# SADDLEHORN RANCH - FILING 2

A PARCEL OF LAND LOCATED IN THE SOUTH HALF OF SECTION 3 AND THE NORTH HALF OF THE NORTH HALF OF SECTION 10  
TOWNSHIP 13 SOUTH, RANGE 64 WEST OF THE 6TH P.M.,  
EL PASO COUNTY, STATE OF COLORADO  
**CONSTRUCTION DOCUMENTS**

SADDLEHORN RANCH -  
FILING 2  
COVER SHEET

SHEET 14 OF 40
JOB NO. 25142.04

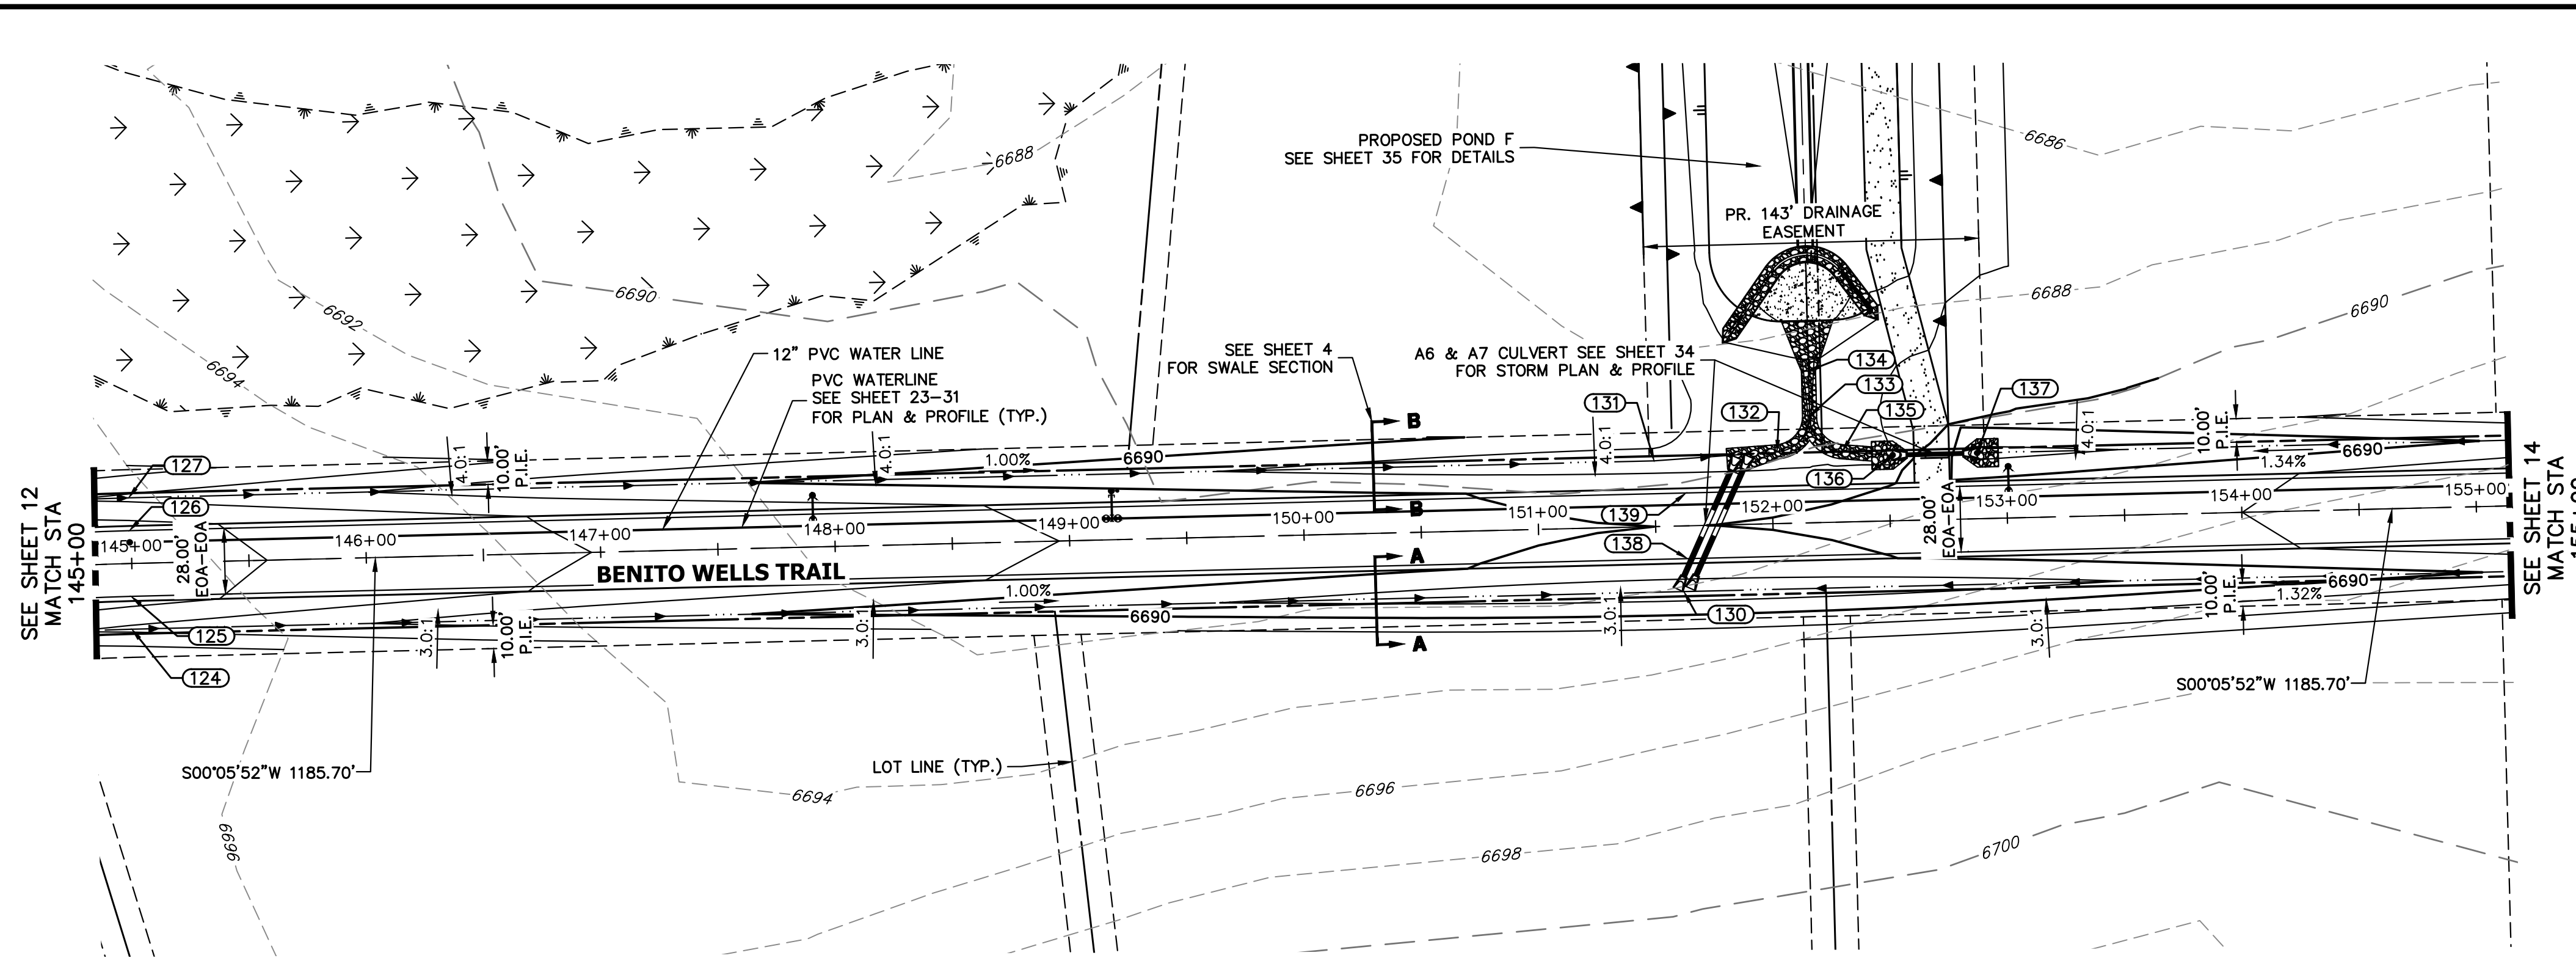
Show 335' sight distance line, it appears that mail kiosk could be in a sight distance triangle and needs to be in a safe location. Moving it to the Lots 6 and 7 common lot line looks like a better location.

Sight distance triangles added to plans and mail box moved to recommended location.
